MORGAN AND MORECAMBE OFFSHORE WIND FARMS: TRANSMISSION ASSETS

Annex 3.2.3 to Response to RR - Environment Agency (RR-677)

Document Reference: S_PD_3.2.3

11 April 2025
F01

Figure 1.6: Watercourse and waterbodies scoped in and survey numbers – Section 5

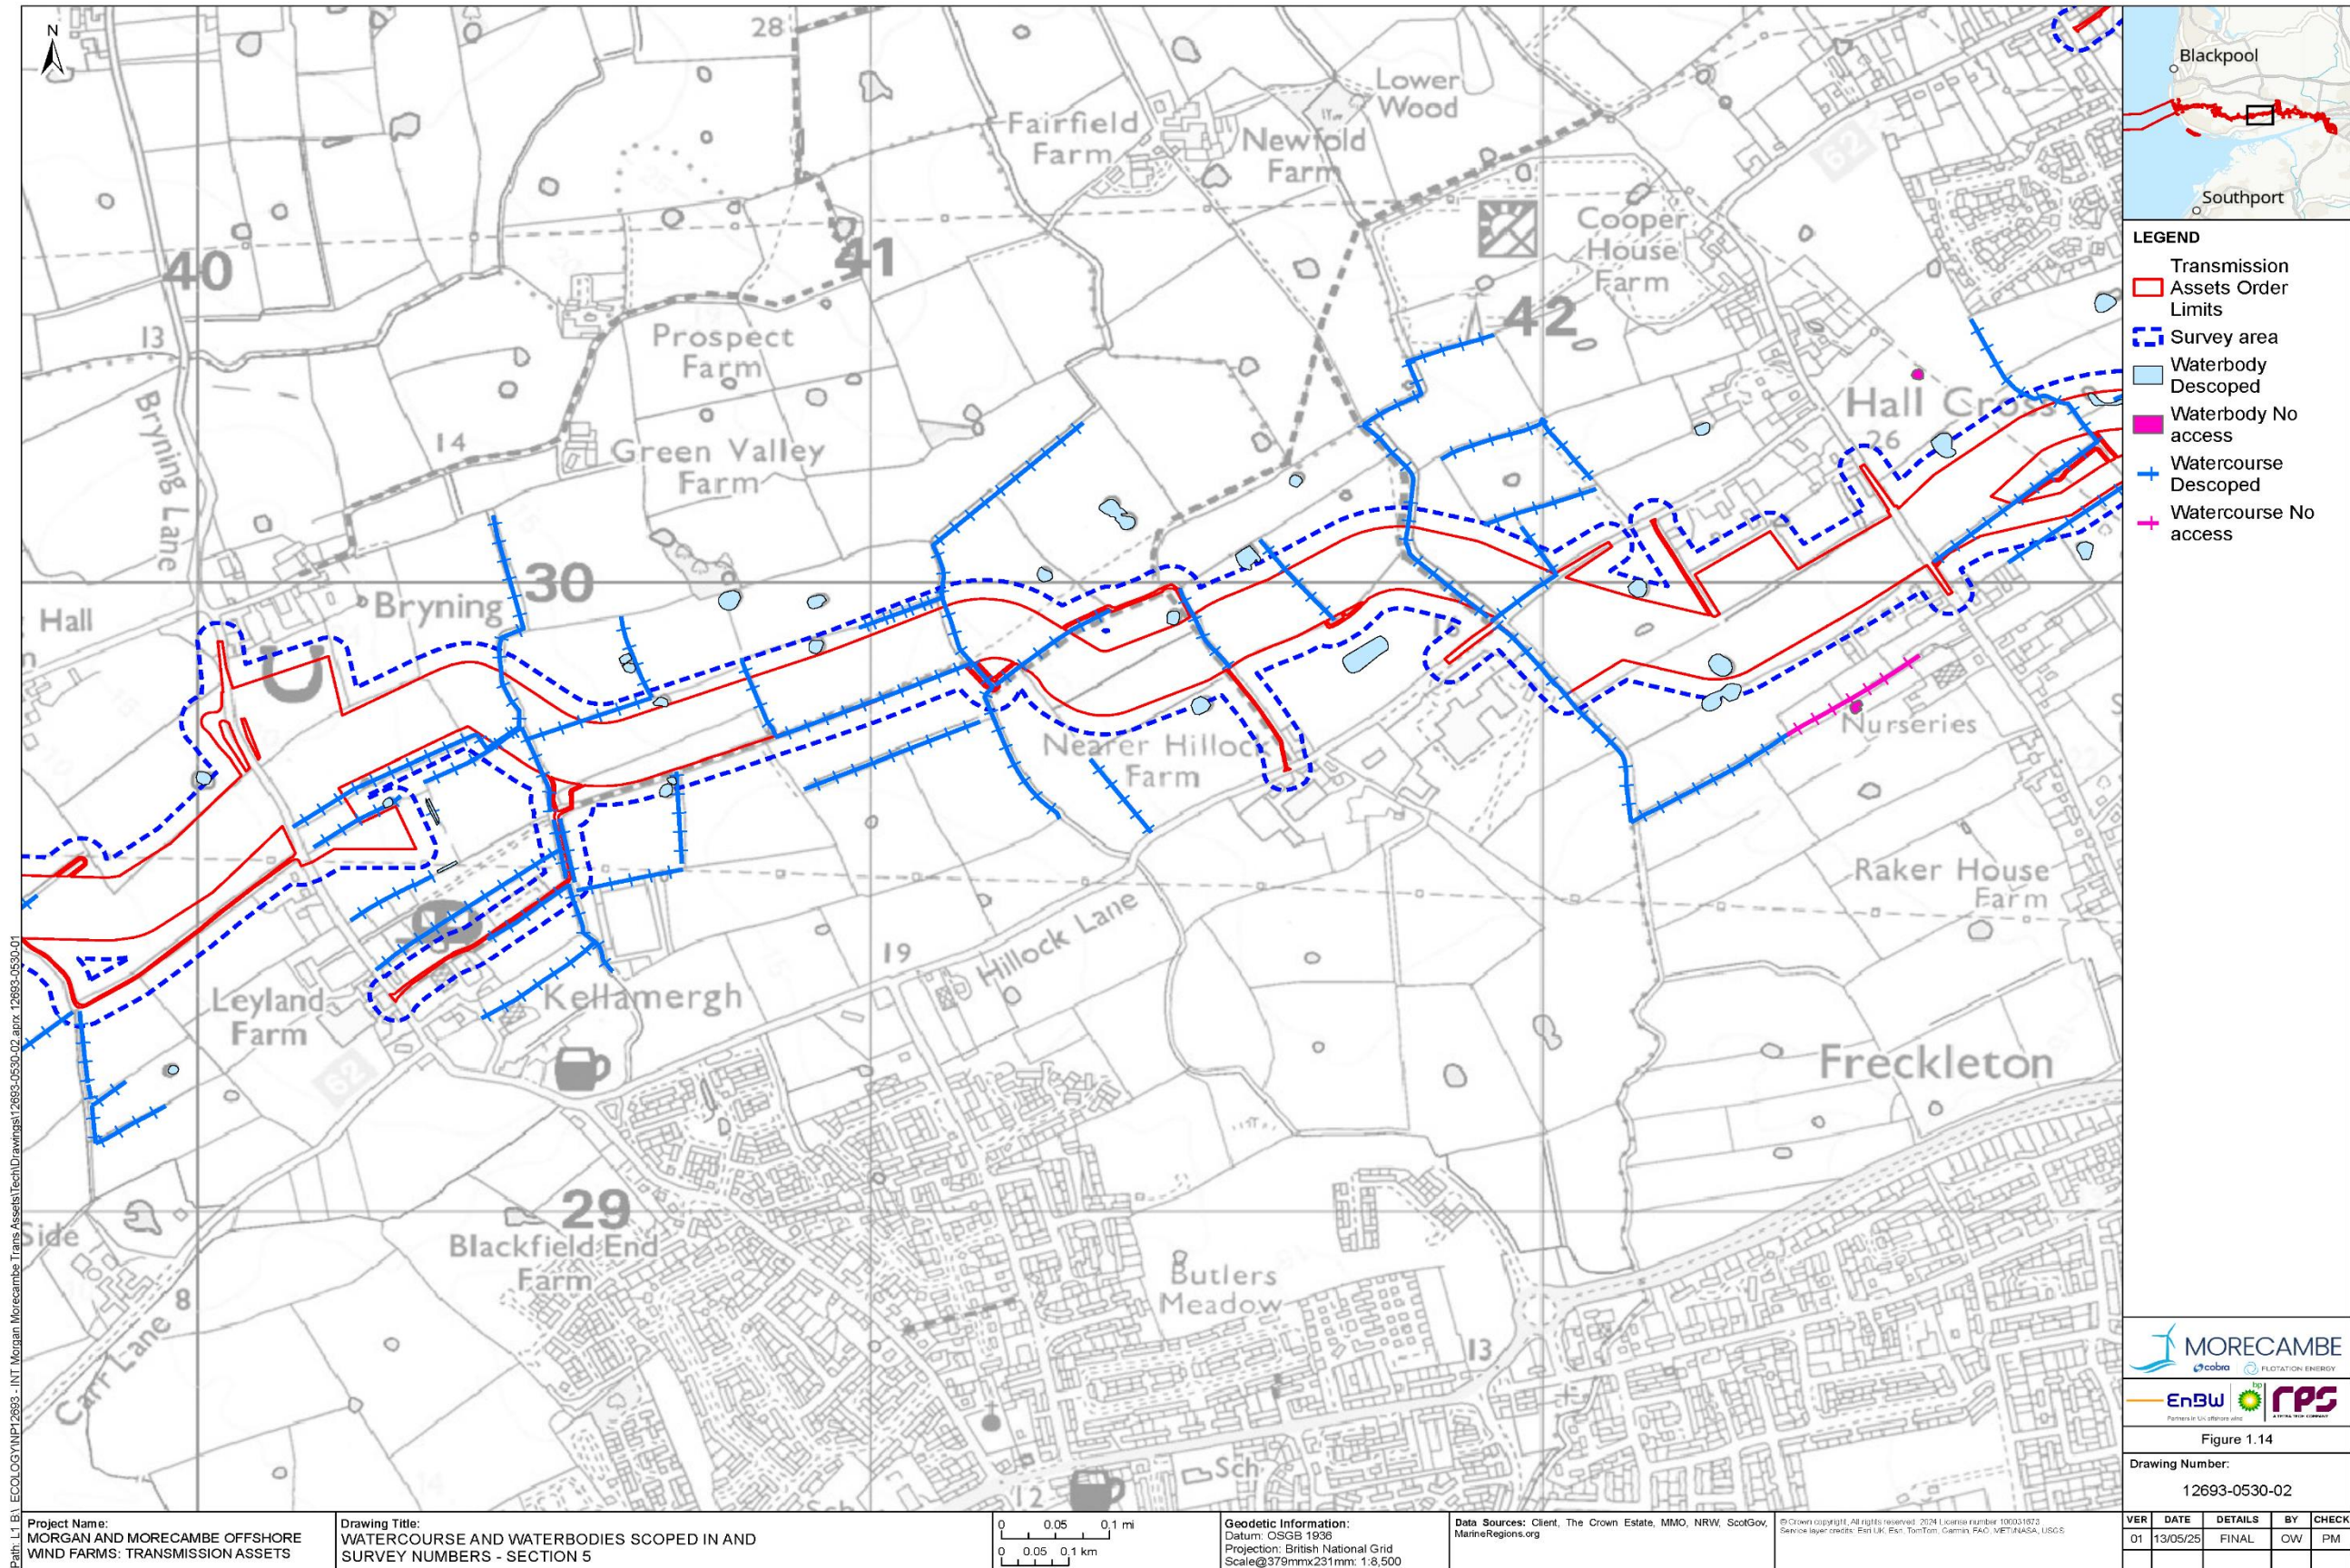
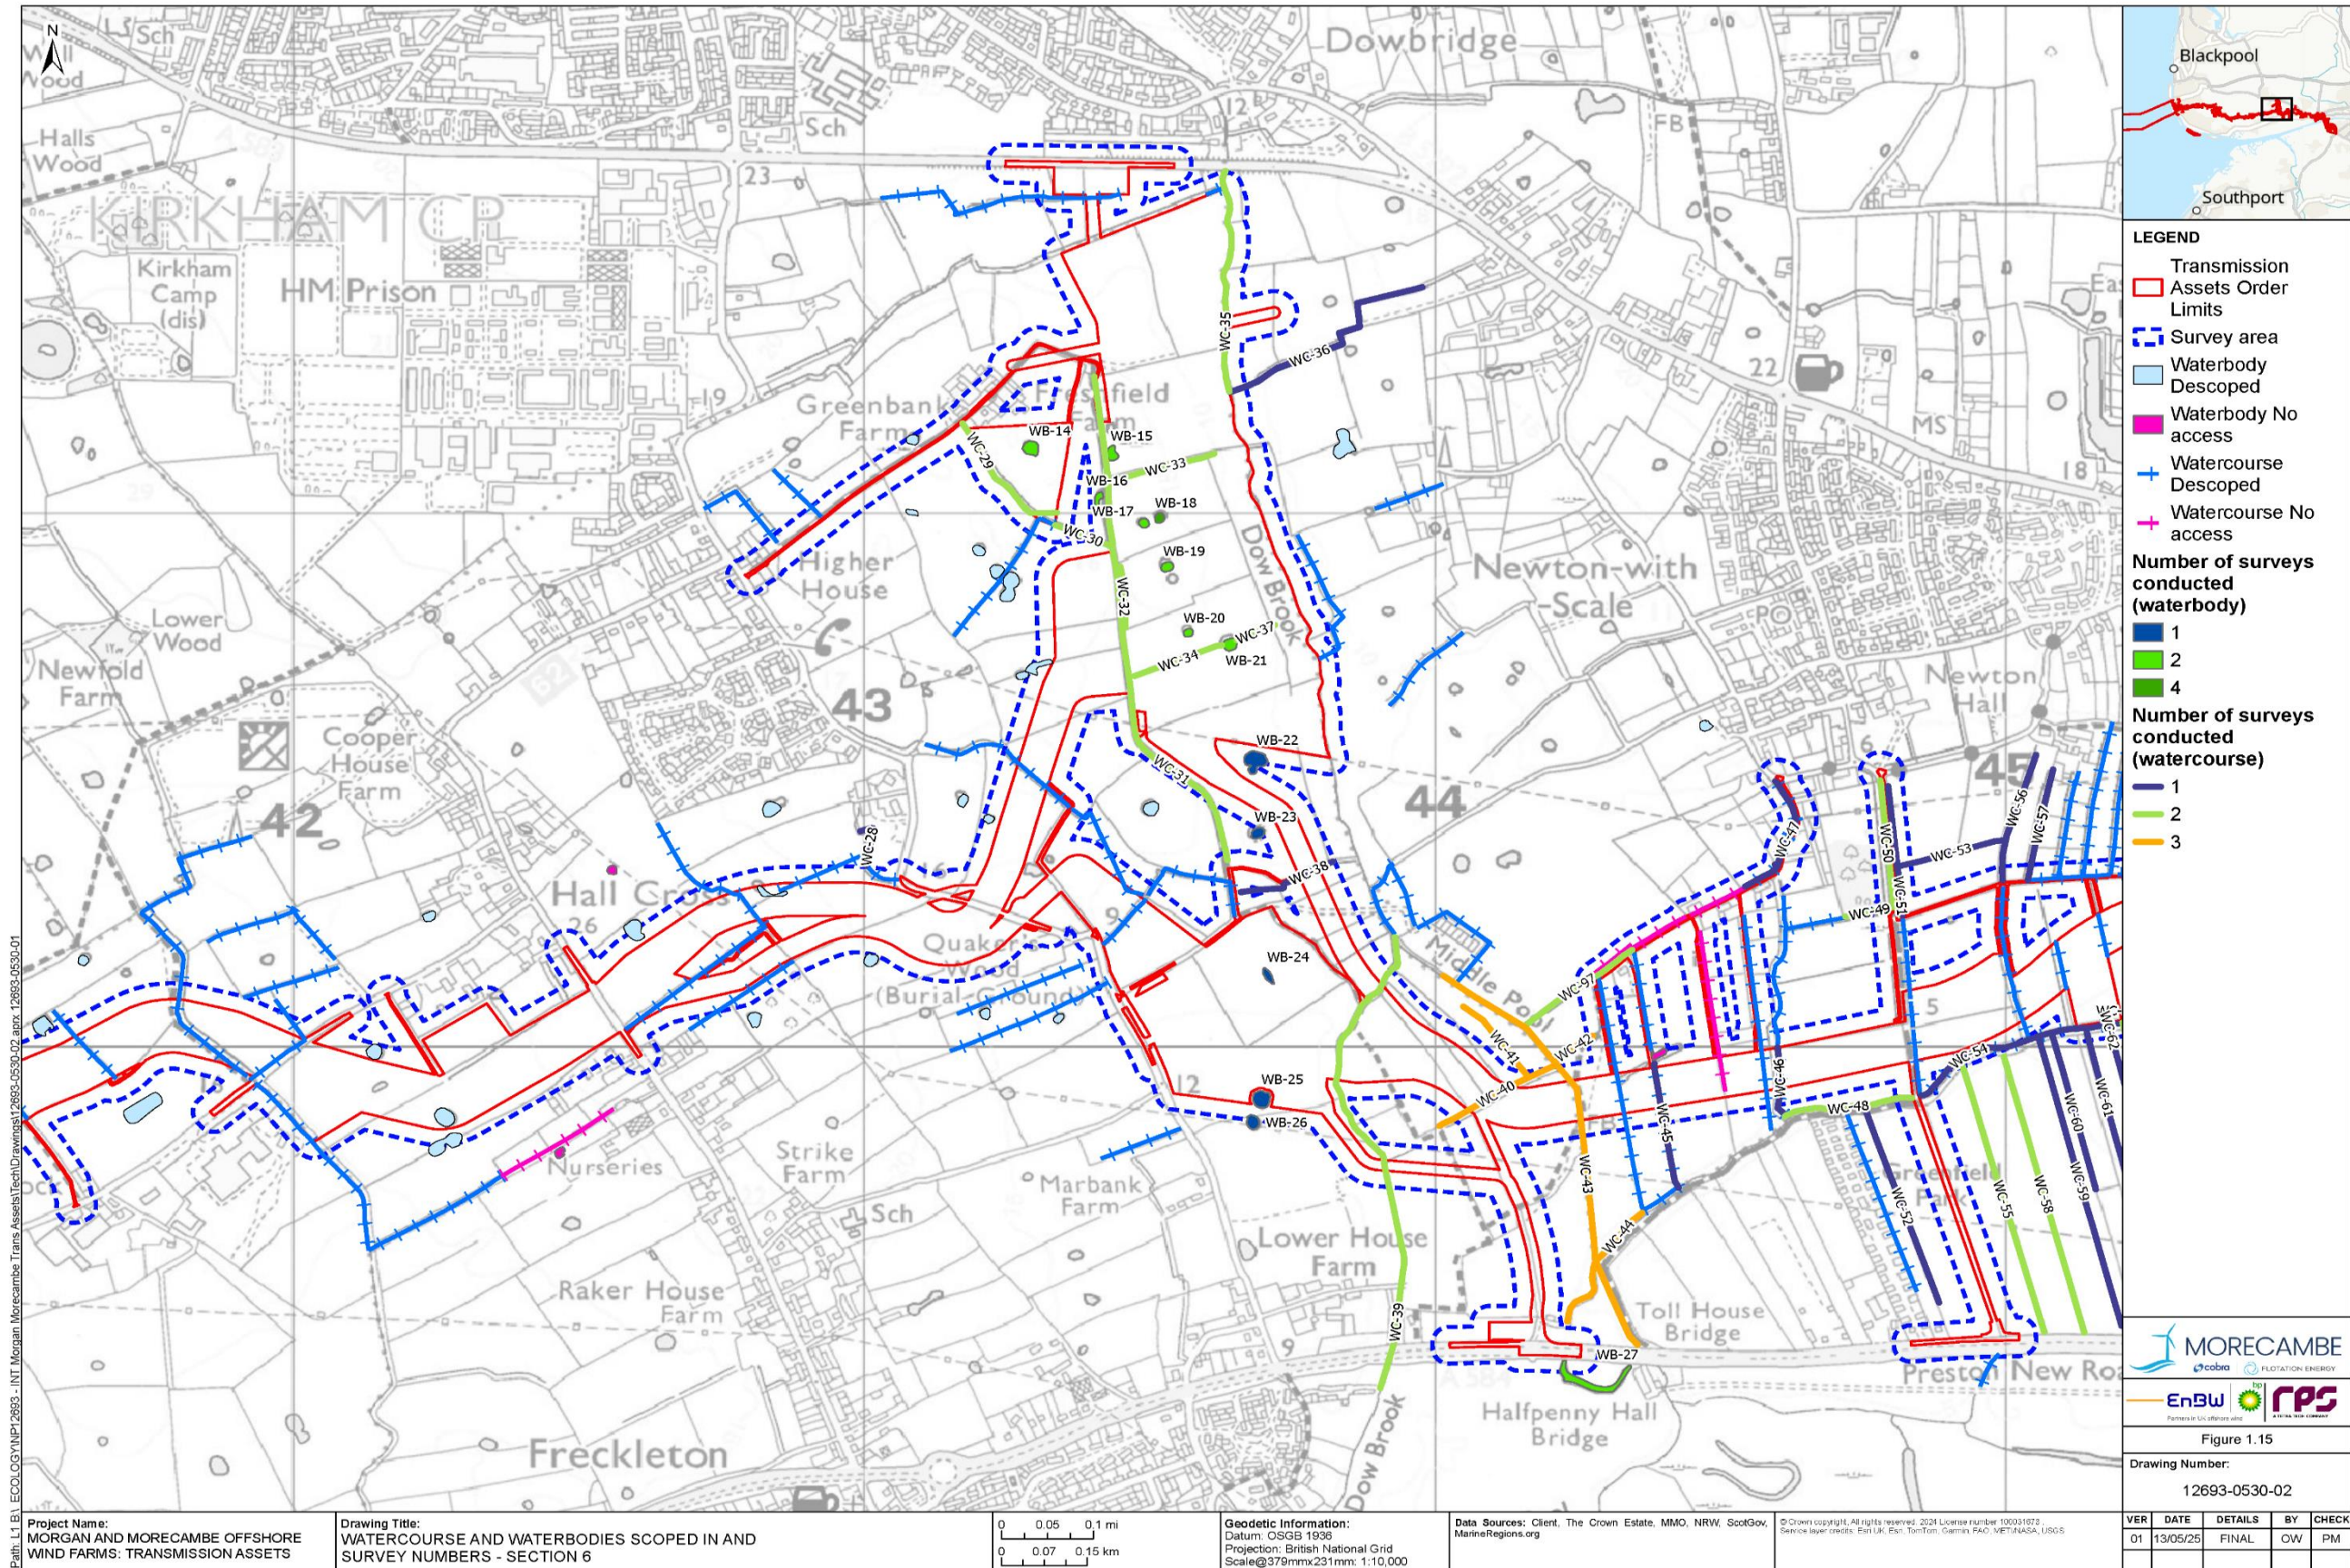
RR-0677 0677.12 (Appen. 1 APP-083)	<p>Water vole survey technical report</p> <p>Section 1.2.4.16 and 1.2.4.17: Water vole surveys have been undertaken following periods of weather extremes. The surveys in June 2023 were undertaken following an extended period of hot dry weather. The survey in April 2024 was undertaken following a period of heavy rainfall.</p> <p>Possible under-recording. Evidence of water vole are less likely to be recorded following dry weather, and evidence may be washed away during heavy rainfall.</p> <p>The report confirms that 'late season' water vole surveys were ongoing at the time of DCO submission. Once complete this report should be updated to reflect the results and submitted for review.</p>	<p>A campaign of water vole surveys was undertaken between April 2023 and July 2024 on land parcels with habitat that could potentially support water vole and where access was agreed. The surveys were undertaken in accordance with the methodology agreed with the Environment Agency (as part of the EWG) and the results were reported in Volume 3, Annex 3.9: Water Vole Survey Technical Report (APP-083). The water vole survey methodology requires two visits within the breeding season (i.e. early season (between mid-April to June) and late season (between July and September)).</p> <p>The Applicants responded to comments regarding the weather conditions during the June 2023 water vole surveys in Table 3.5 of Volume 3, Chapter 3: Onshore Ecology (APP-075) and subsequent surveys were undertaken in 2024 where access was permitted. A summary of the surveys (as set in Table 3.15 of APP-075) found there was little confirmed evidence of water vole and (together with the infrequent but widespread evidence of mink) considered water vole to be of local importance within the survey area. However, a precautionary approach was adopted for the assessment which assumed that water voles to be present where potentially suitable habitat had been recorded.</p> <p>The Applicants confirm that water vole surveys were undertaken in late August, September 2024 and the first week of October 2024 (as weather conditions allowed the</p>

Reference	Relevant Representation Comment	Applicants' response
		<p>surveys to be recorded as a 'late season' survey). These surveys formed part of the late season surveys that were being completed in accordance with the seasonal survey restrictions and the methodology of the previous water vole surveys. Given the timing of the surveys, the results were not included in the DCO application.</p> <p>The Applicants confirm that Volume 3, Annex 3.9: Water Vole Survey Technical Report (APP-083) will be updated to show the location of these surveys and will be submitted at Deadline 1 of the DCO Examination. The Applicants confirm that no new evidence of water voles was recorded during the late August to early October surveys and therefore, the characterisation of the baseline and the conclusion of the assessment as reported in Volume 3, Chapter 3: Onshore Ecology (APP-075) remain unchanged.</p> <p>Preconstruction surveys for European Protected Species (including water vole) will be undertaken (as secured in Requirement 13 of Schedules 2A & 2B the draft DCO (AS-004)). As set out in the Outline Ecological Management Plan (OEMP) (APP-212) the water vole surveys will be undertaken along all ditches of potential value to water voles that would be affected during construction.</p>
